Project Name: 4 Unit Condo Project

Project Address: 31 Fore Str.

Project Name: **Construction of new four-unit residential condominium building**
Level III Subdivision and Site Plan
Project #: #2016-005
Address: 31 Fore Street, Portland
CBL: 016 J026001
Applicant: Peninsula Property Development
Planner: Jean Fraser

SUBDIVISION PLAT
31 FORE STREET REDEVELOPMENT
 PENINSULA PROPERTY DEVELOPMENT, LLC.
 59 MODOY STREET, PORTLAND MAINE 04101

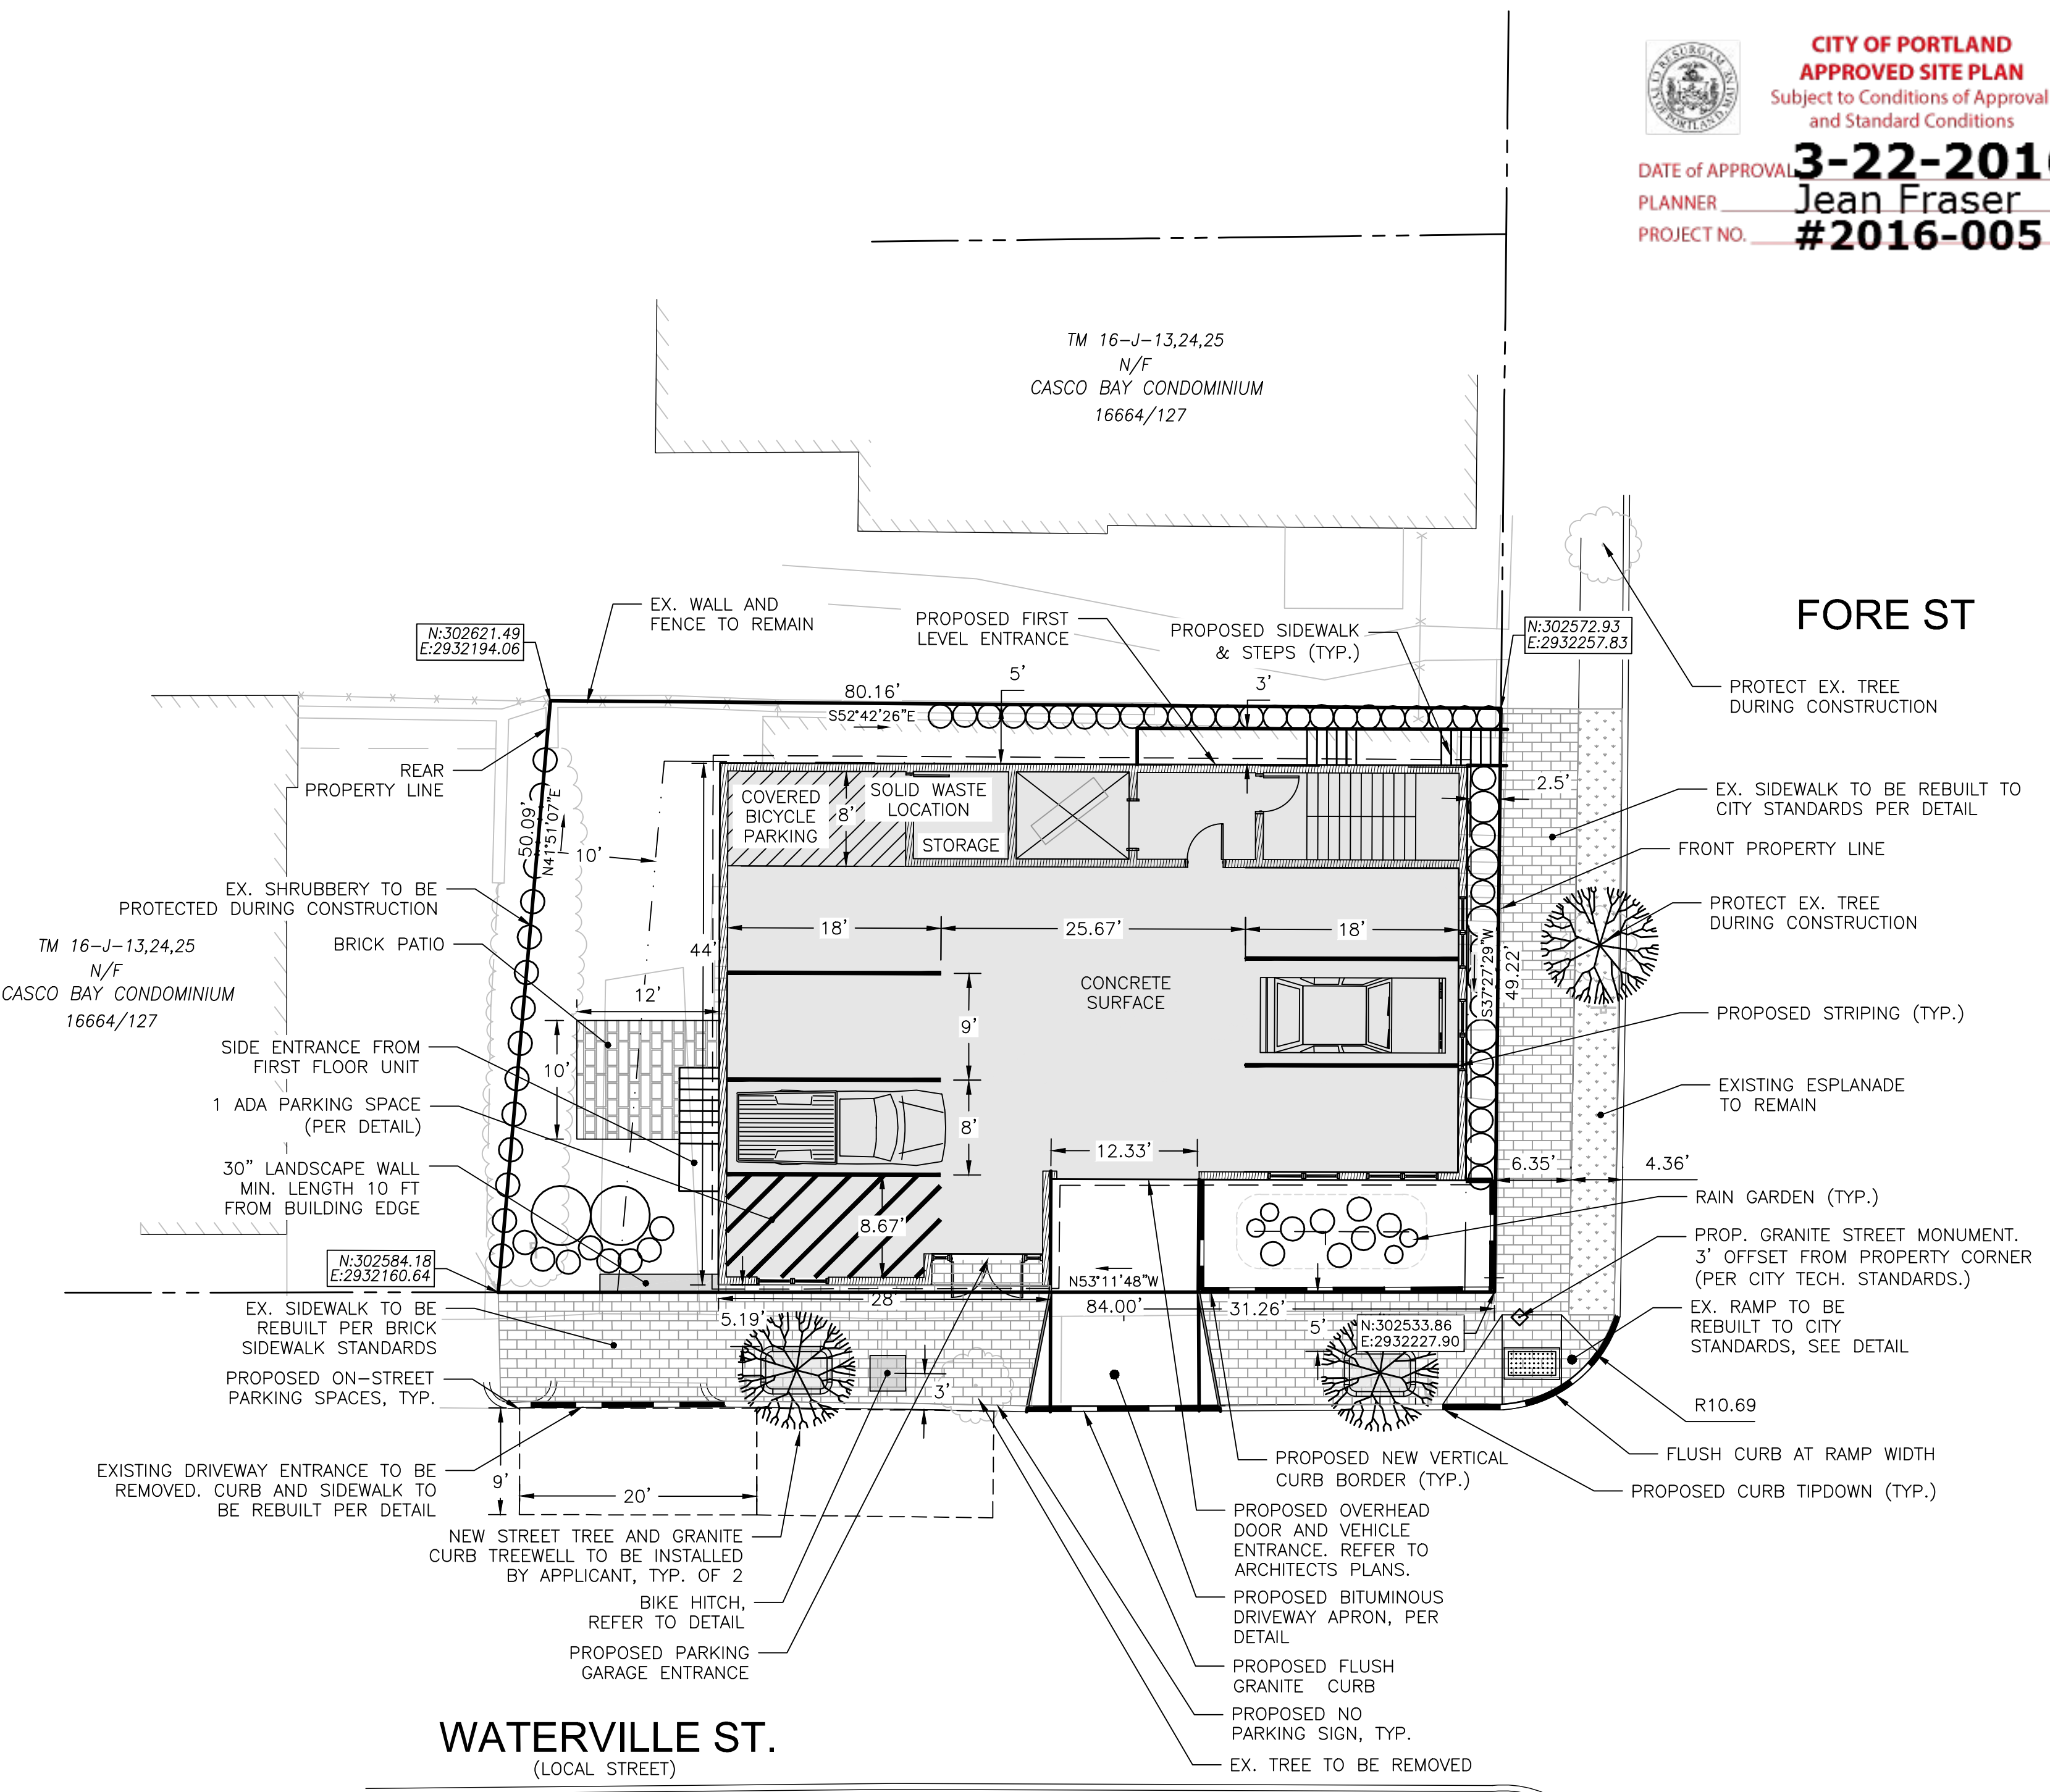
4. **The recording Plat is not stamped by a profession surveyor as required. Please submit stamped Plat.**

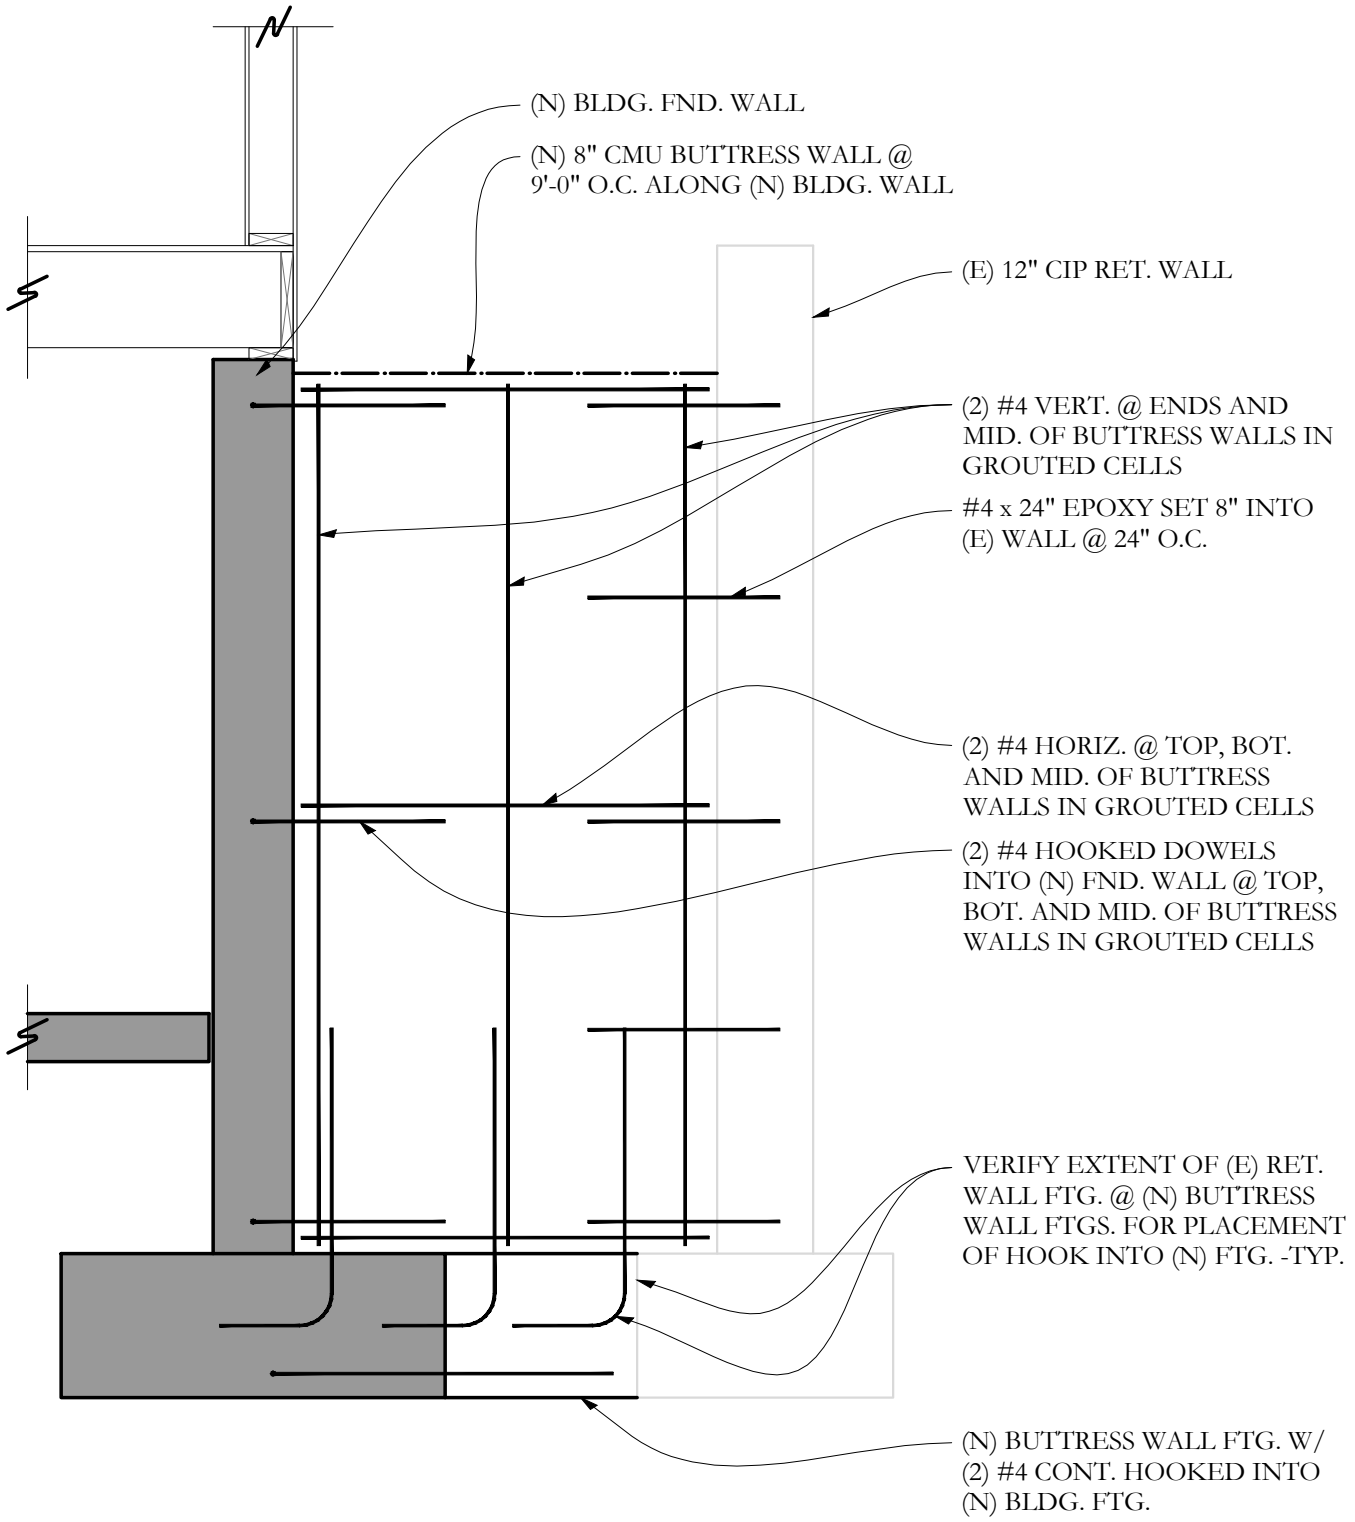
- The applicant shall provide a construction management plan for review and approval.

Status: Additional detail on the construction plan is required, particularly as it relates to potential sidewalk closures and contractor parking. I suggest that this be a condition of approval with a plan being submitted for review and approval prior to issuance of any City permits.
